PLANNING STATEMENT

Scholes Lane - ST HELENS

SUMMARY OF CHANGES FROM
APPROVED DRAWINGS

**1** General-Arrangement\_Plan\_02-Second  
1:100

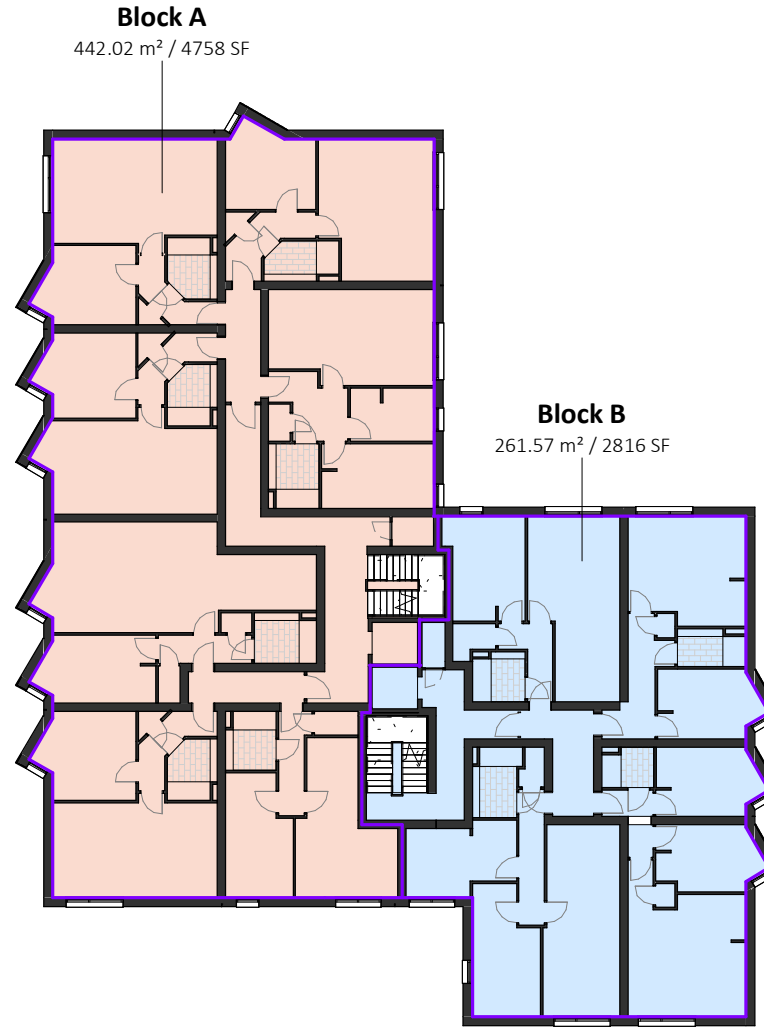
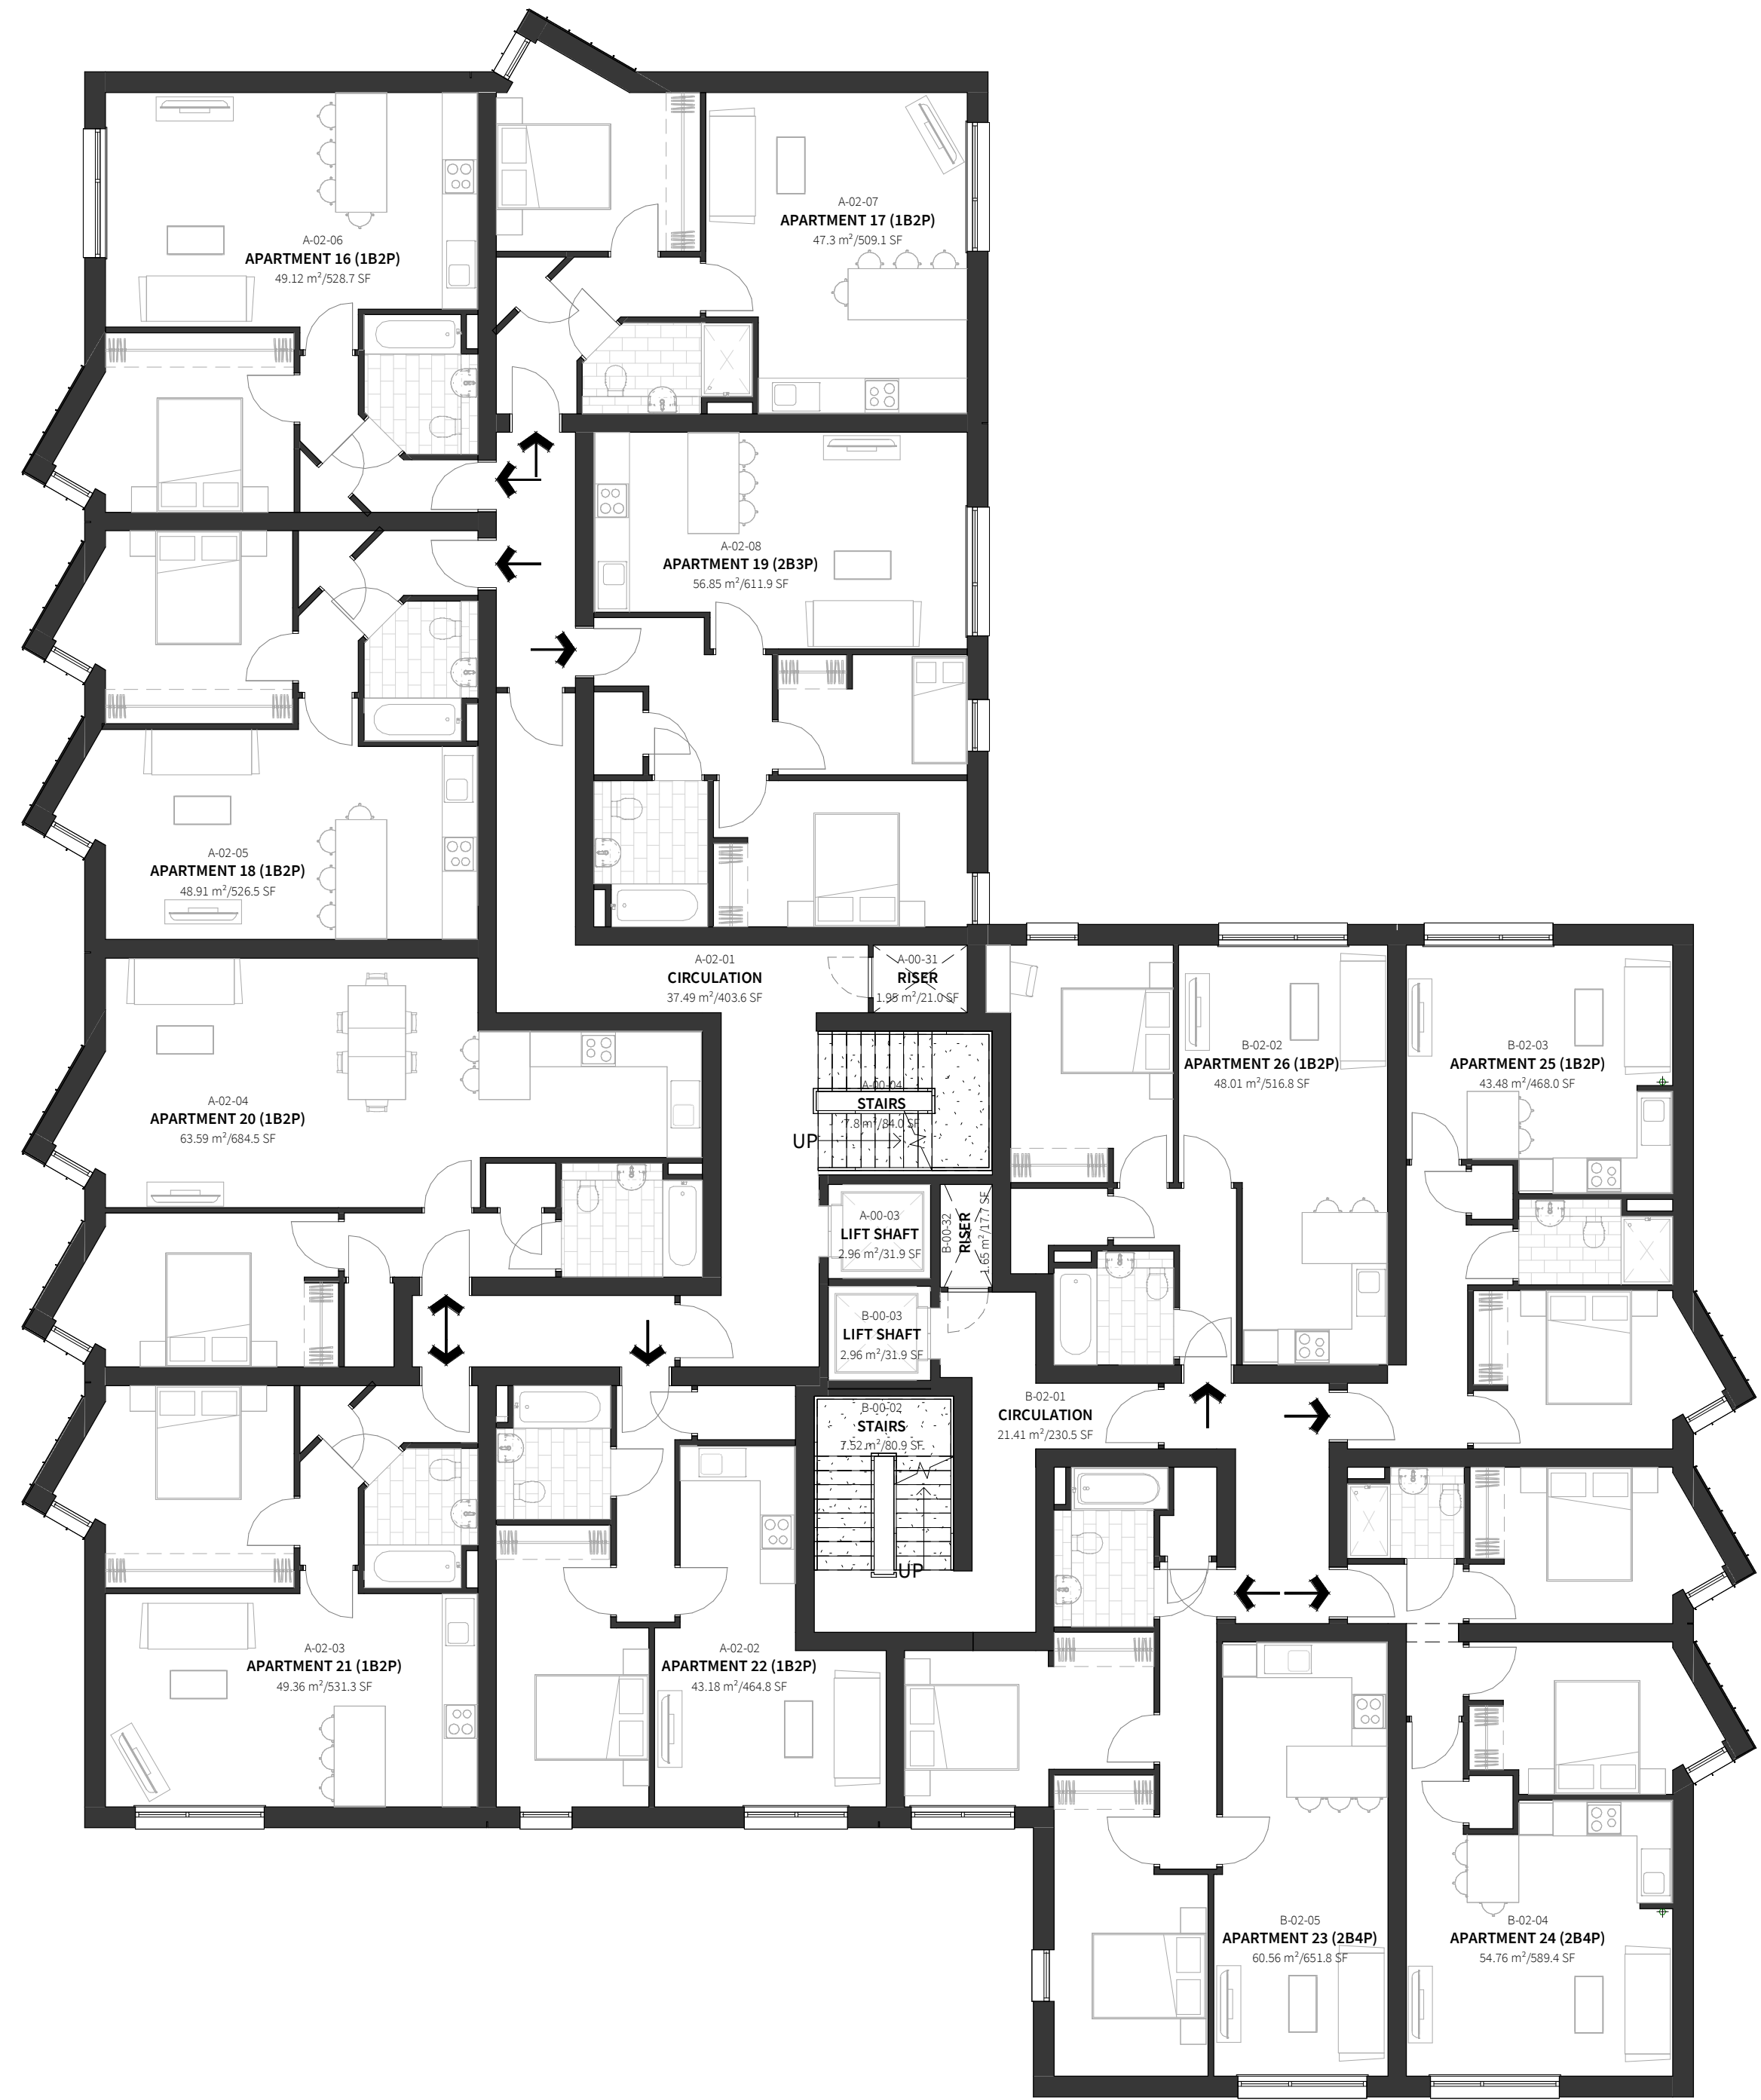
5. Apartment layouts across the floor plate have been made more efficient by reducing the corridors within the apartments. This efficiency has also been achieved through the addition of the second stair and lift. The removal of the bike store allows for an increas

**1** General-Arrangement\_Plan\_00-Ground  
1:100

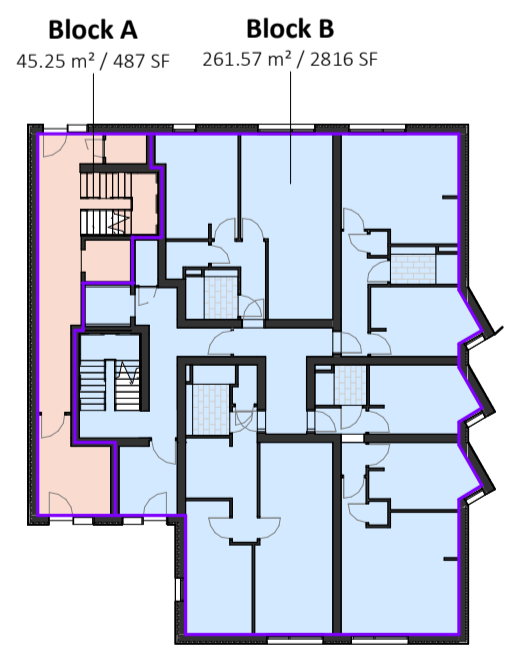
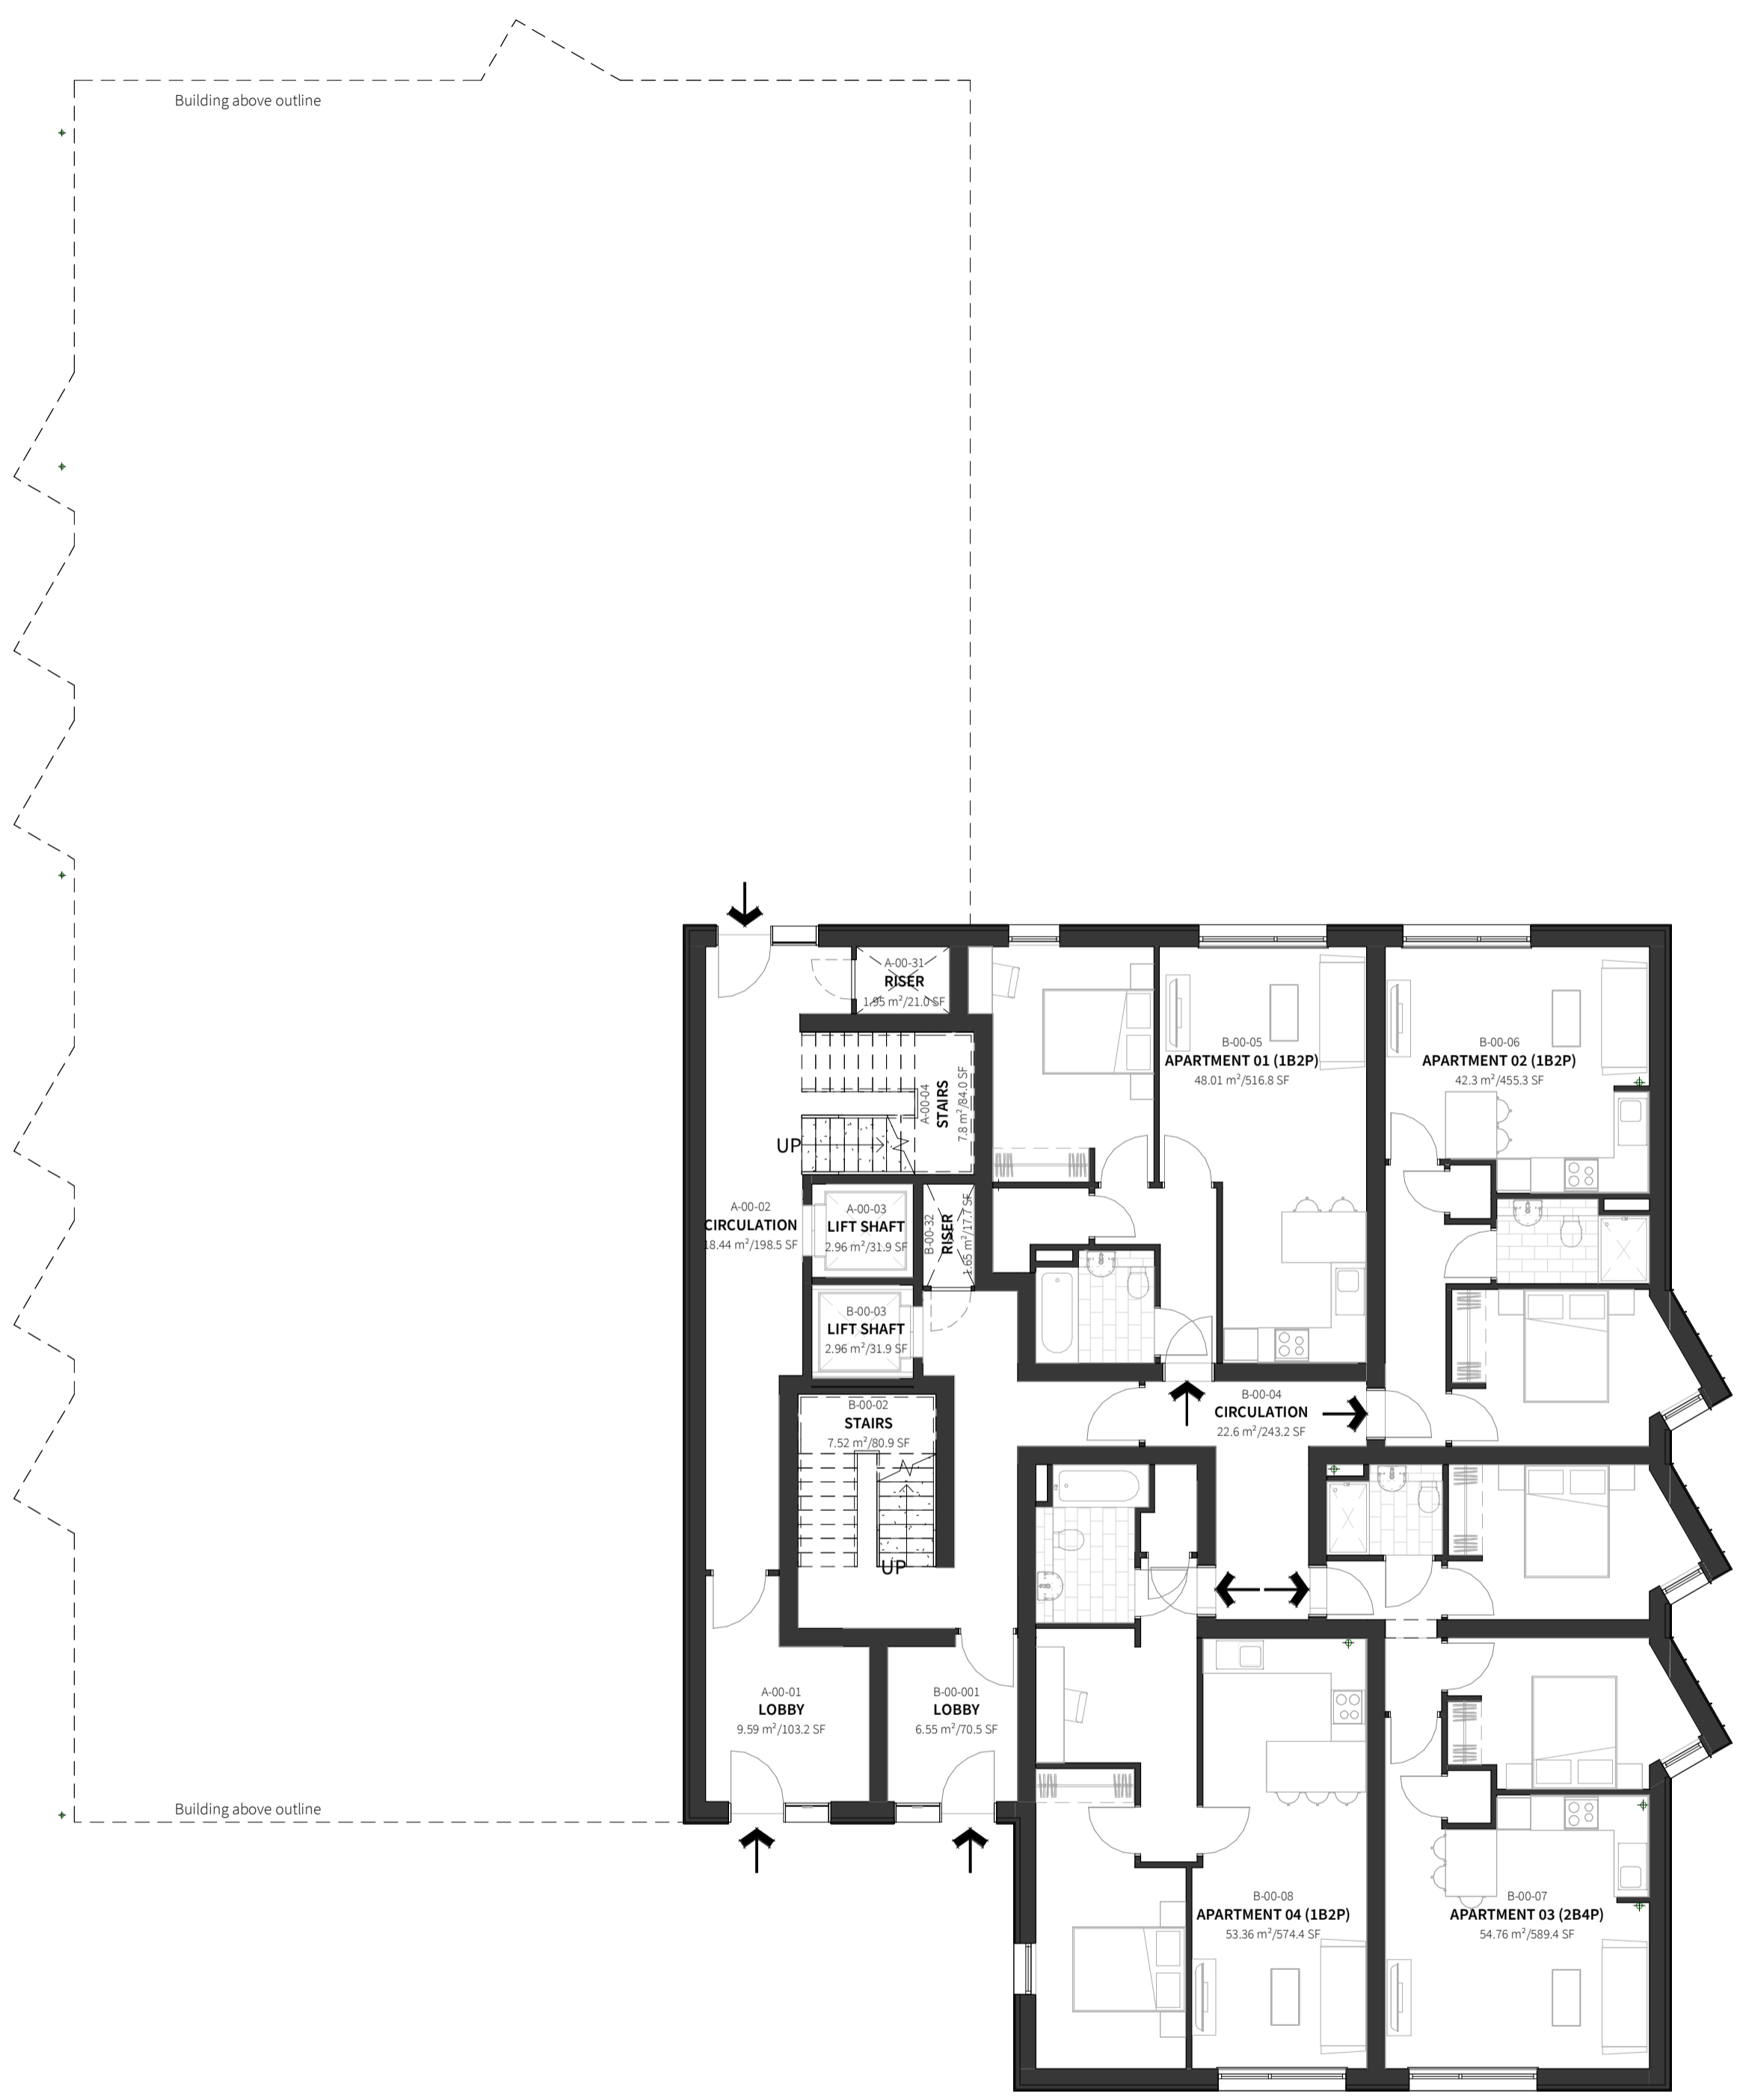
1. Car access to the rear remains the same but the pedestrian access moves slightly to the west.
2. Bike store has moved externally into the parking area as before the bike stores were on every level and took up too much space.
3. The Bin store is an external element now as previously took up too much space in the built structure.
4. The building has two separate entrances and two lifts to serve the two sections of the building creating a more efficient layout with better apartments.
